**FOWLER CREEK GUEST RANCH
EXHIBIT 19
DEPARTMENT MEETING RESPONSE LETTERS**

Meeting Memo

Regarding: Comments Regarding Proposed Fowler Creek Guest Ranch

FOWLER CREEK GUEST RANCH
EXHIBIT 12
EMERGENCY INGRESS AND EGRESS PLAN

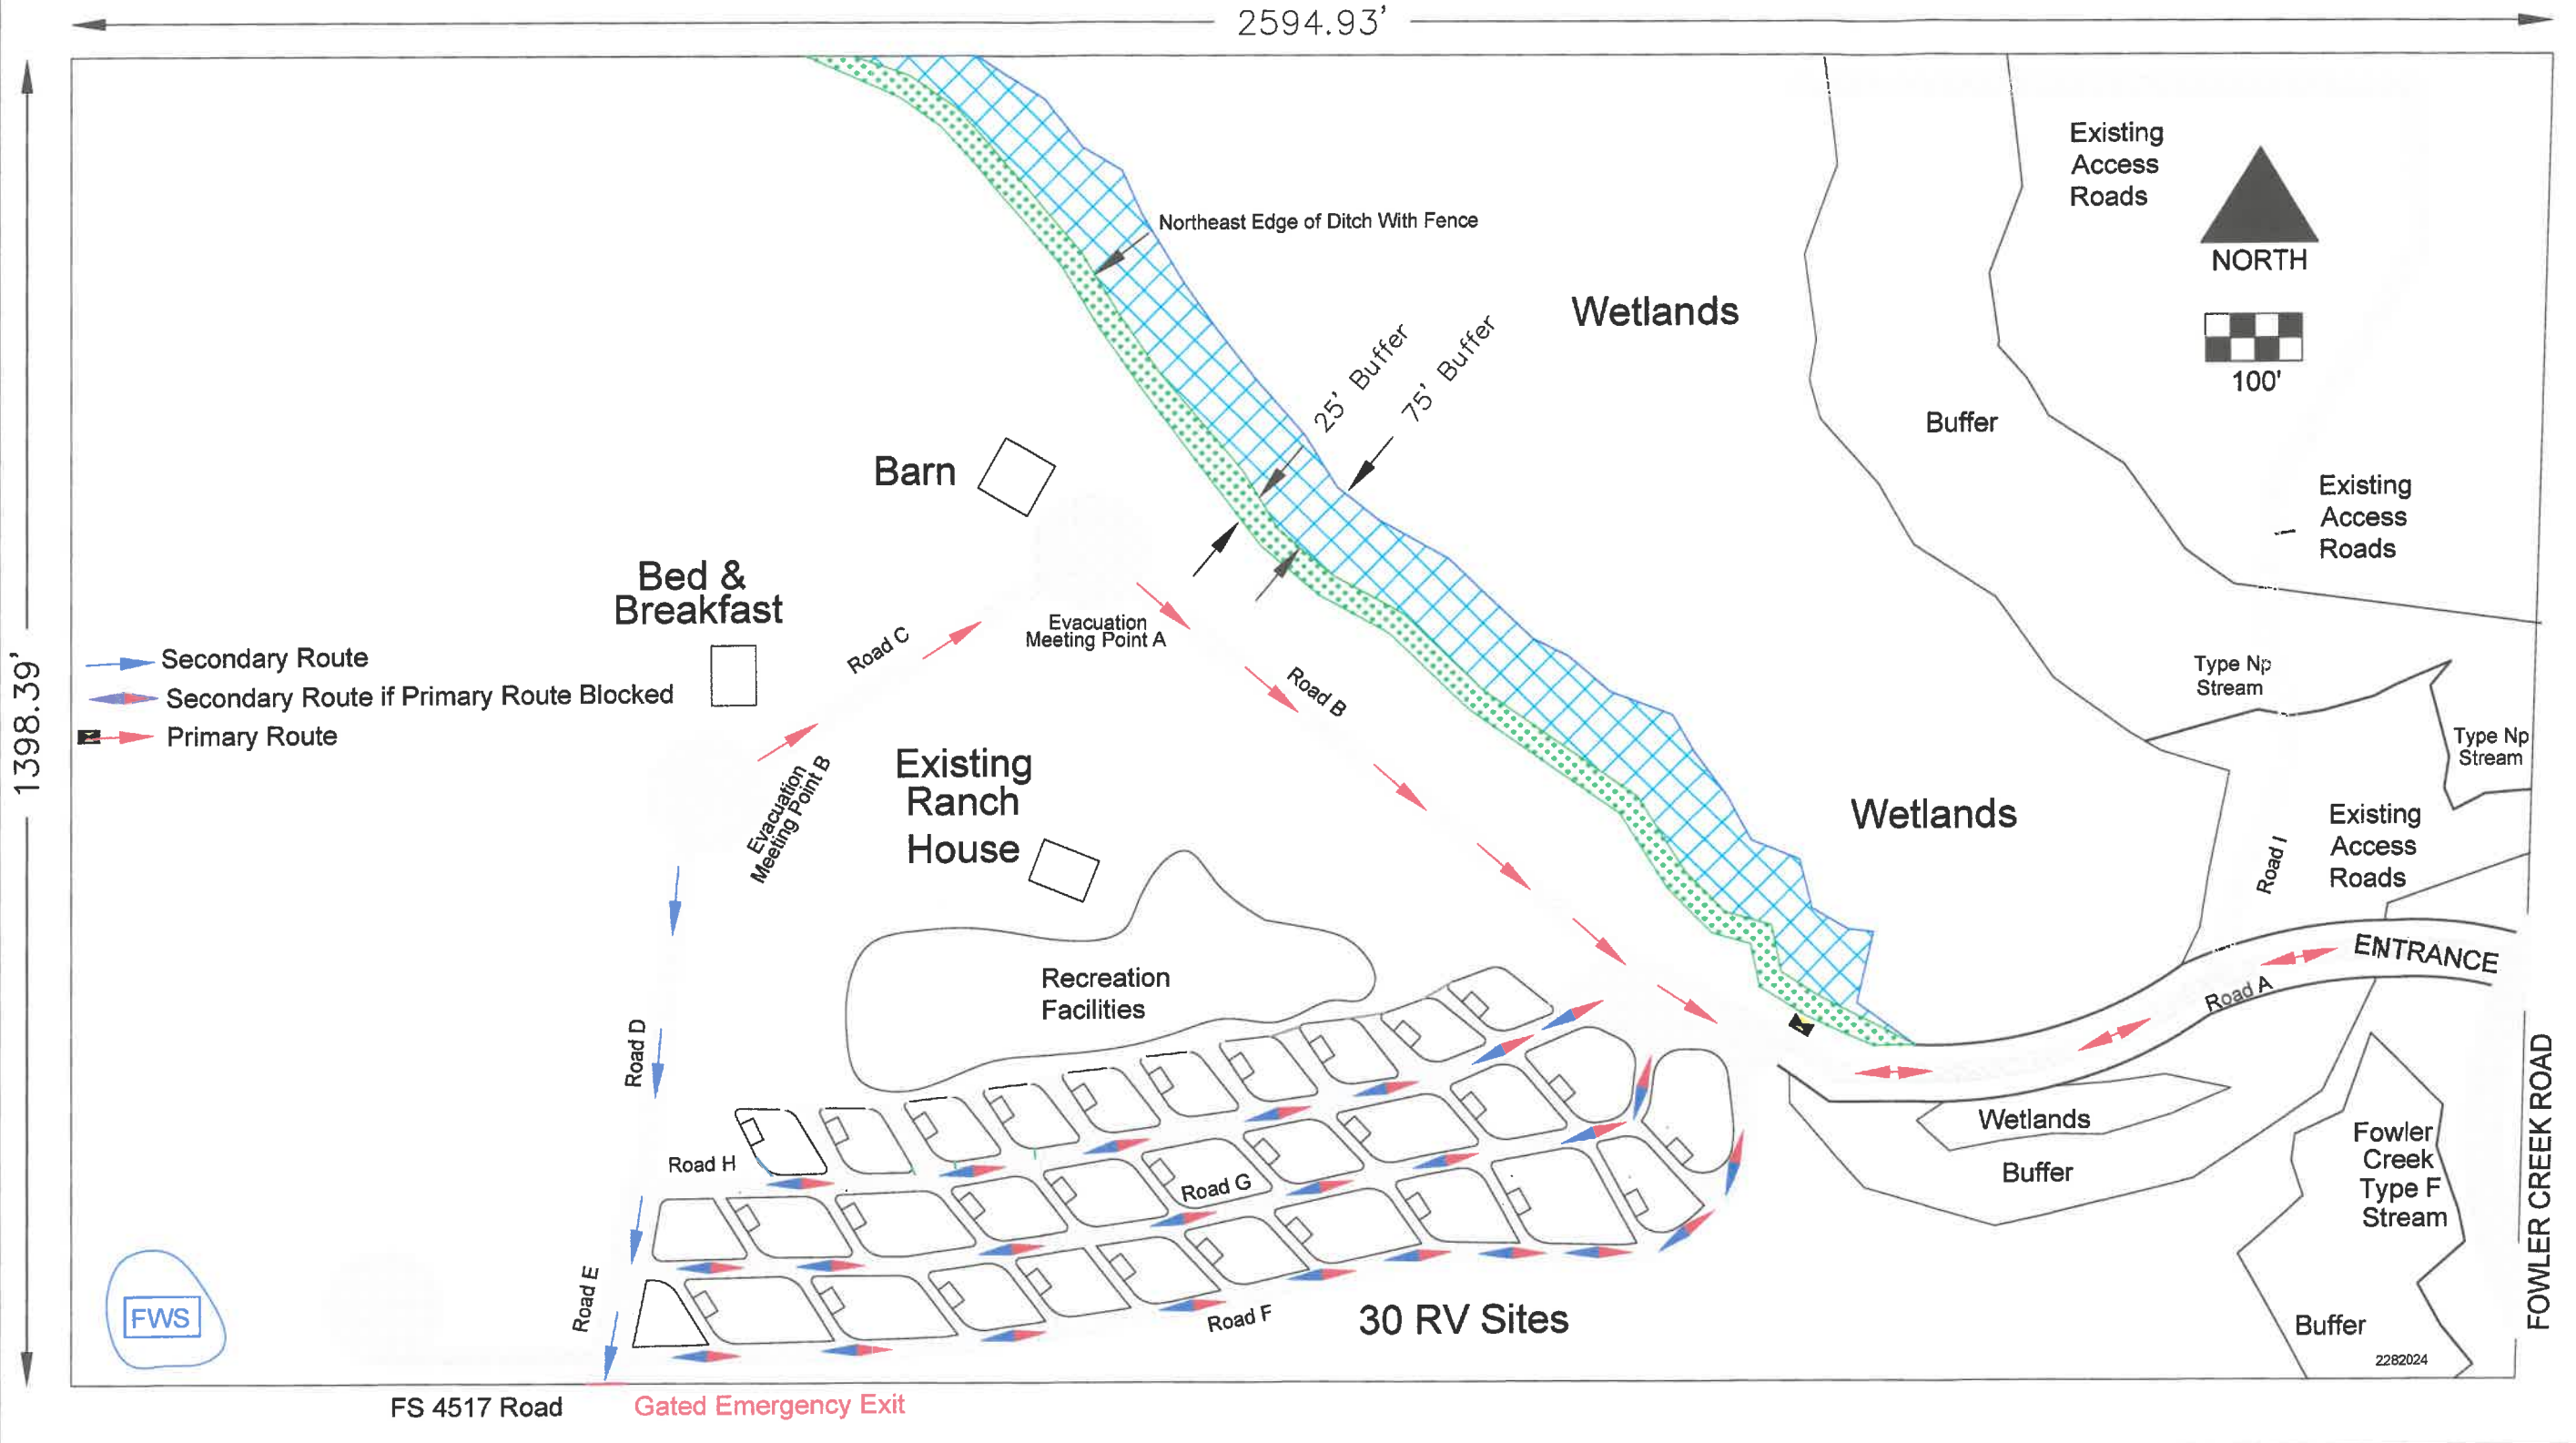
I also share Chief Sinclair's concerns over emergency response egress and access.

My largest fear as it exists today is the lack of available emergency evacuation routes from FS RD 4517. If we more than double the existing population of that community, especially without ANY proposed updates to existing road infrastructure, I fear for the lives of my family and my community in an emergency.

- B. Access Points from Public Roads:** The main entrance and exit for Fowler Creek Guest Ranch is located on Fowler Creek Road. The second access point will be an emergency exit with a breakaway barrier gate on FS Road 4517. In the case of an emergency, this exit will be primarily reserved for emergency services and vehicles and may be used by those individuals located to the south of the guest ranch if the east portion of FS Road 4517 becomes blocked for any reason. These roads are shown on the attached Emergency Ingress and Egress Plan in Exhibit 12.

- C. Internal Road Circulation:** The road configuration in Exhibit 12 also shows plans to design and construct a loop that runs through all guest ranch facilities. This loop road system, along with two added cul-de-sacs, provides bidirectional escape routes for swift evacuation in any direction and will be maintained and prominently marked to ensure safety. These roads will be built at a minimum of 20 feet in width and will follow the guidelines of the International Fire Code Appendix D.
